From: Contact Centre (CRM) <contact@ribblevalley.gov.uk>
Sent: 18 December 2025 08:55
To: Planning
Subject: Planning Application Comments - 3/2025/0794 FS-Case-774703952

Planning Application Reference No.: 3/2025/0794

Address of Development: Old Dairy Farm, Chipping Road, Chaigley, BB7 3LS

Location Plan

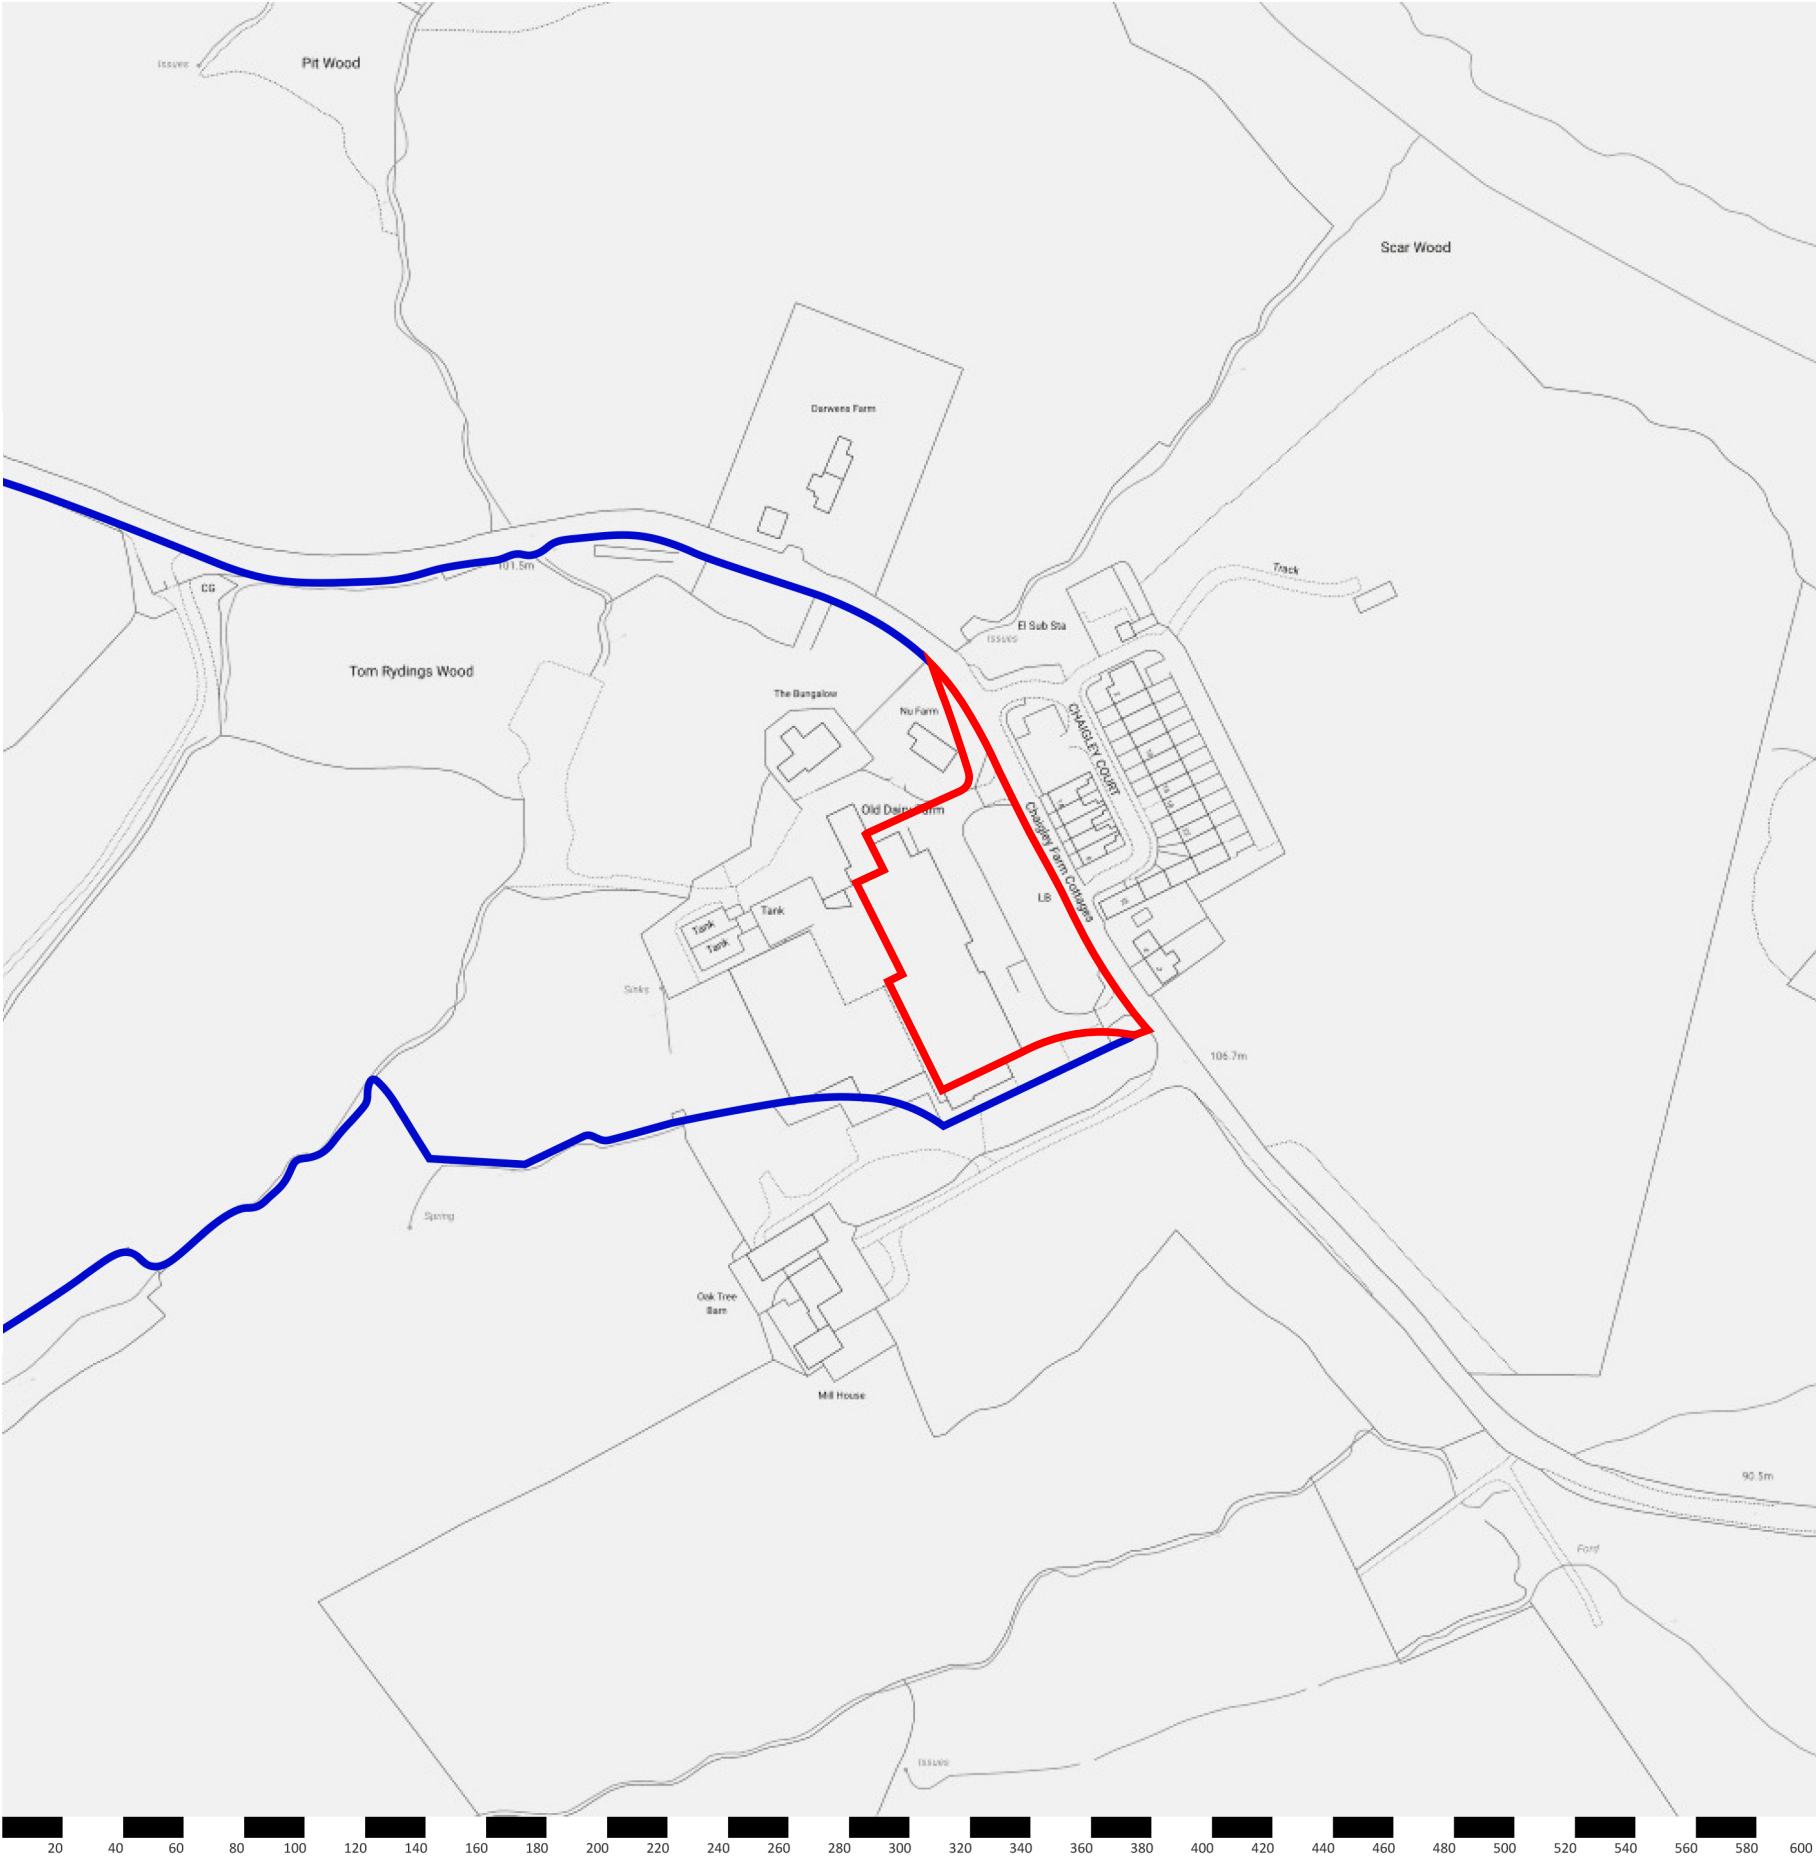
It would appear that the amended planning application is for one large building housing offices - it is not clear if these are for the use of one business or will be occupied by several businesses - plus increased parking spaces from 26spaces on the original application to 30 spaces on the amended application plus a small bike shed / storage unit.

2. The number of parking spaces allocated on the plans submitted seems wholly inadequate based on the

number of units planned. Also the car parking space seems to be quite tight making manoeuvring difficult.

5. The proposed entrance to the new units at Old Dairy Farm is currently not used to access the farm. However it

is often used by people accessing some of the properties opposite to safely manoeuvre vehicles into their drive

way. If this is to be a vehicle entrance to Old Dairy Farm then we can envisage a higher risk of

accidents for those who live opposite and indeed people slowing down to turn into Chaigley Court.
